Project # 1009982

RE: project 1009982, 14EPC- 40012 and 14EPC-40014

FEDEX GROUND ALBUQUERQUE

**RE: RESPONSES TO EPC CONDITIONS OF APPROVAL
FEDEX GROUND EPC PROJECT # 1009982
14EPC-40012 SITE DEVELOPMENT PLAN FOR SUBDIVISION
14EPC-40014 SITE DEVELOPMENT PLAN FOR BUILDING PERMIT**

FEDEX GROUND ALBUQUERQUE, NM	DRAWN BY DY
	SITE PLAN FOR SUBDIVISION	DATE 5/19/14
TIERRA WEST, LLC 5571 MIDWAY PARK PLACE NE ALBUQUERQUE, NM 87109 (505) 858-3100 www.tierrowestllc.com	2013075-SPSE	SHEET # 1 OF 1
RONALD R. BOHANNAN P.E. #7868		JOB # 2013075

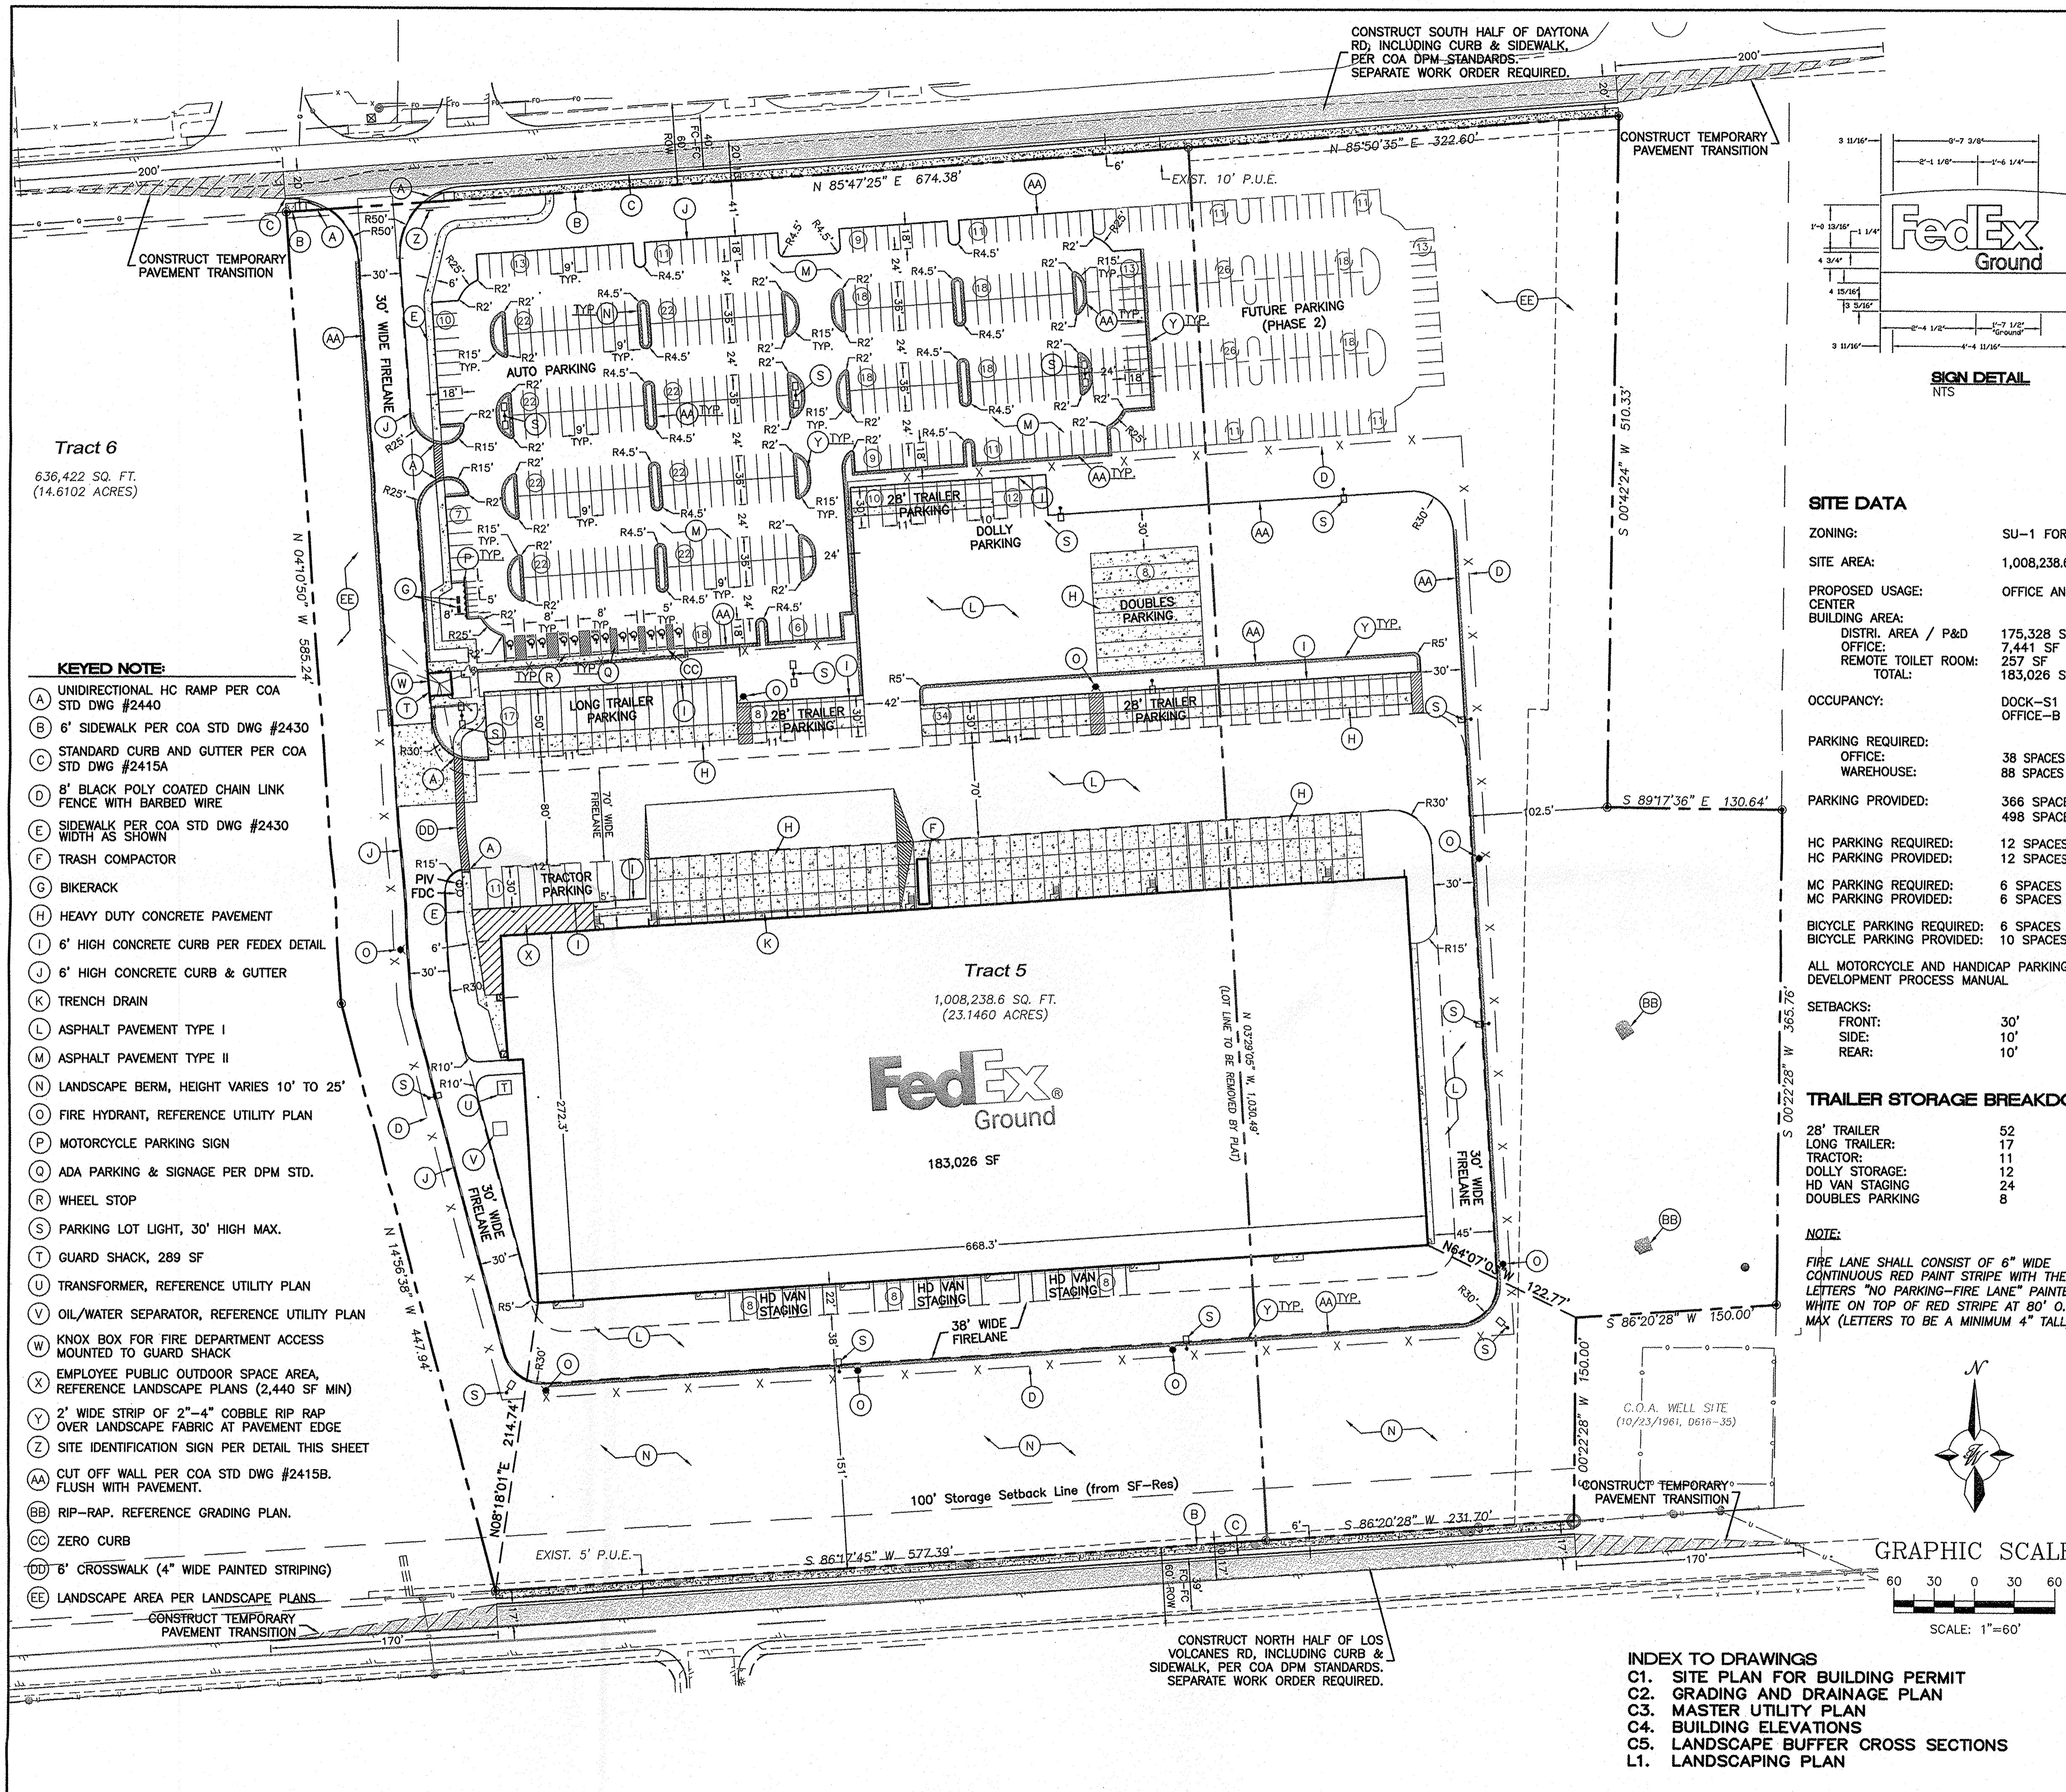
6. The Site Development Plan shall comply with the General Regulations of the Zoning Code, the Subdivision Ordinance, and all other applicable design regulations, except as specifically approved by the EPC. **OK**
7. On sheet 1 of 1, under Pedestrian and Vehicular Ingress and Egress, replace the last sentence with the following "The design and location of the access points as show is conceptual". Future access shall be reviewed and approved at the time of Site Development Plan for Building Permit. *A note with similar wording was added to sheet 1 of 1. This fulfills the condition.*

RESPONSE: Tract 6 was removed from the Site Plan for Subdivision since it has already been platted as part of the Bulk Plat. The clarification for access to the property is no longer required. Access to this tract will be reviewed by the EPC as part of the future Site Plan for Building Permit submittal.

FEDEX GROUND ALBUQUERQUE, NM	DRAWN BY DY DATE 5/16/14
	SITE PLAN FOR BUILDING PERMIT	2013075-SPE
	TIERRA WEST, LLC 5571 MIDWAY PARK PLACE NE ALBUQUERQUE, NM 87109 (505) 858-3100 www.tierrawestllc.com	SHEET # C1 JOB # 2013075

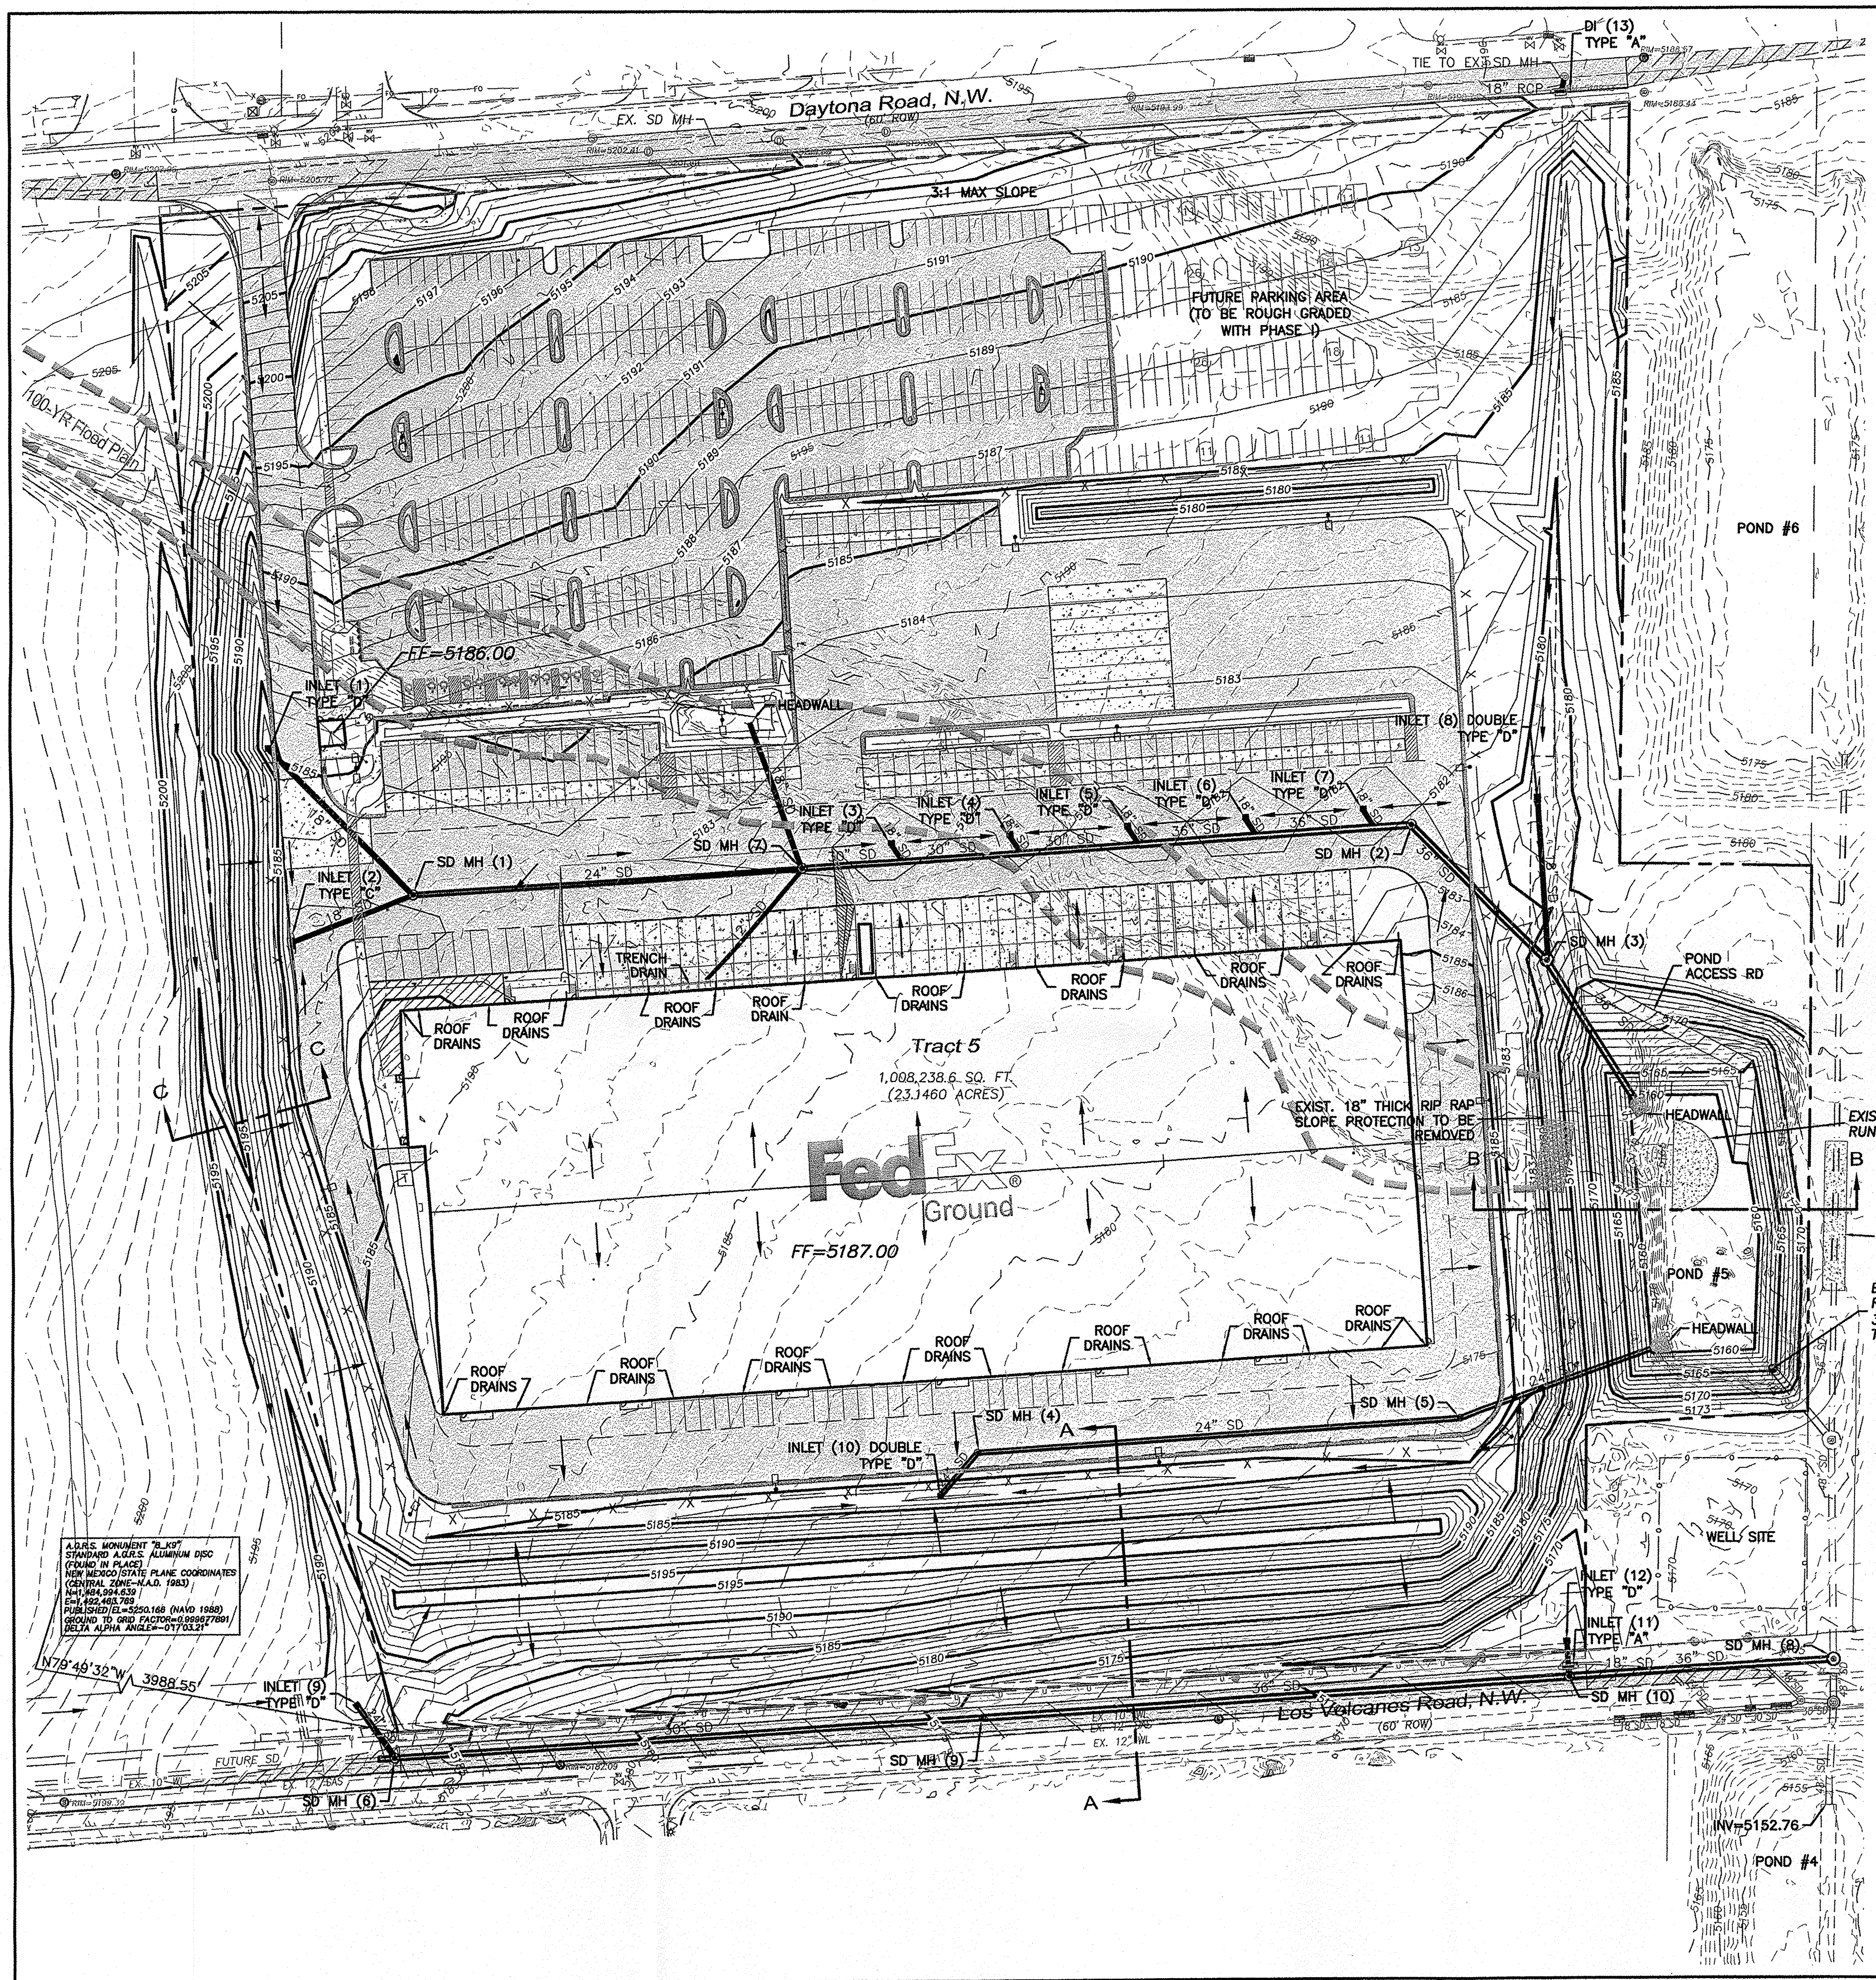
6. RECOMMENDED CONDITIONS FROM CITY ENGINEER, MUNICIPAL DEVELOPMENT and NMDOT:
 1. Infrastructure requirements will be determined at DRB. **OK**
 2. Additional dimensioning (width of motorcycle parking stalls, height of curb, width of sidewalk) must be provided prior to approval. **OK**
